<b>Consultation Response from KC, Trees</b>
<b>2025/90708 Land at, Merchant Fields Farm, off Hunsworth Lane, Cleckheaton</b>
<b>Discharge of details reserved by conditions 3 (Construction (Environmental) Management Plan), 6 (Temporary surface water management details), 8 (Proposed internal adoptable roads), 9 (Permanent site entrance details), 16 (Surface water attenuation details), 17 (Details of Swale/ditch management), 19 (Phase II Site Investigation details), 20 (Remediation Strategy), 25 (Noise Impact Assessment), 30 (Arboricultural Method Statement/ Tree Protection Plan), 34 (Biodiversity Gain Plan) of permission 2024/91260 for Variation of conditions 2 (plans and specifications) and 35 (removal of permitted development rights) on previous permission 2021/92801 for erection of 291 dwellings with associated works and access from Hunsworth Lane and Kilroyd Drive – revisions to house types, unit size mix and layout</b>

<b>Date Responded: 25/07/2025 Responding Officer: Hazel Irving Responding Ref:SP2/70</b>

**Appendix 5:
Tree Constraints Plan**

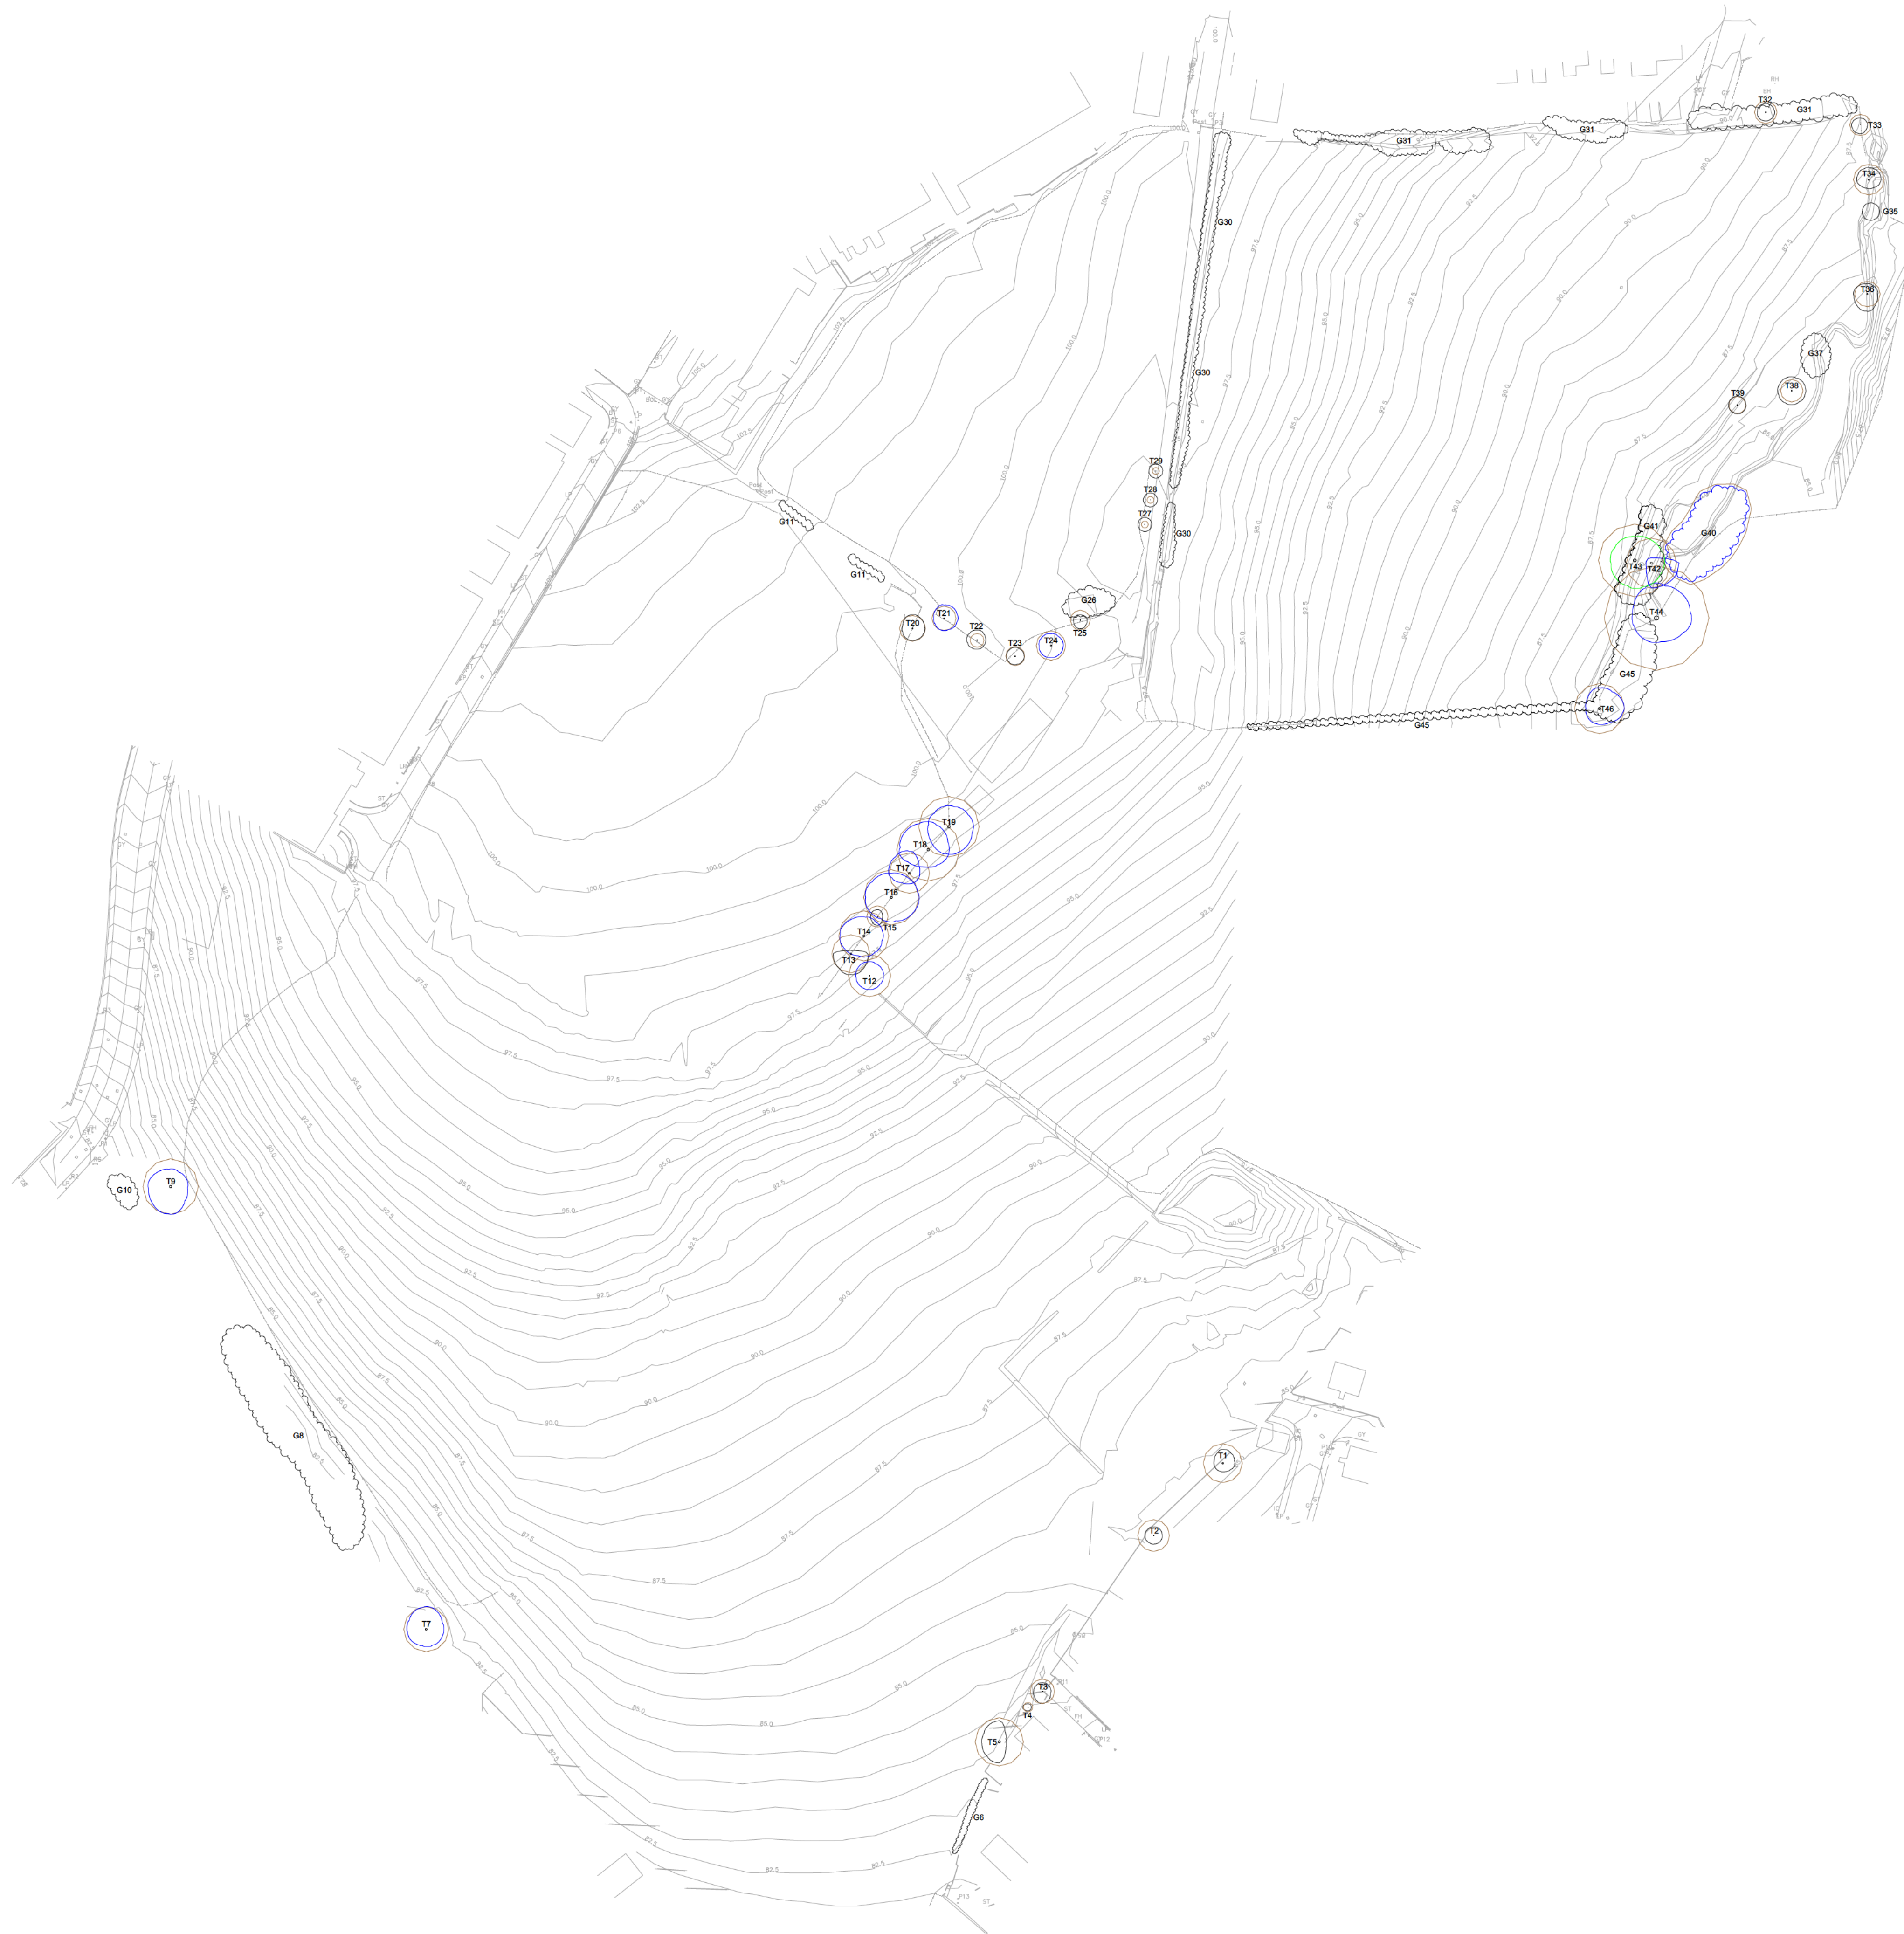
Applicant has resubmitted the original Tree Survey produced by AWA, dated August 2019 along with a Tree Protection Fencing Plan (drawing number 122-TP-001 #) produced by Harron Homes, dated 10/05/2025.

The plan has not been produced by an appropriately qualified professional, to BS5837 Standard and there is no accompanying Arboricultural Method Statement, as required to satisfy Condition 30.

- There is no redline boundary on the submitted TPF plan
- Proposals not shown on the plan.
- TPF aligned through the canopies of boundary vegetation
- No RPAs shown on the plan for any of the Cat C tree groups.
- Trees and hedges not adequately protected include: T5, G8, T27, T28, T29, G30, G31, T33, T34, G35, T36, G37, T38, T39T43, T44 G45, or T46.
- T34 protected by TPO SP2/70/g12 is not adequately protected.

To satisfy Condition 30 please have an AMS and Tree Protection plan produced in accordance with BS5837:2012 as required. This must be produced by an appropriately qualified professional.
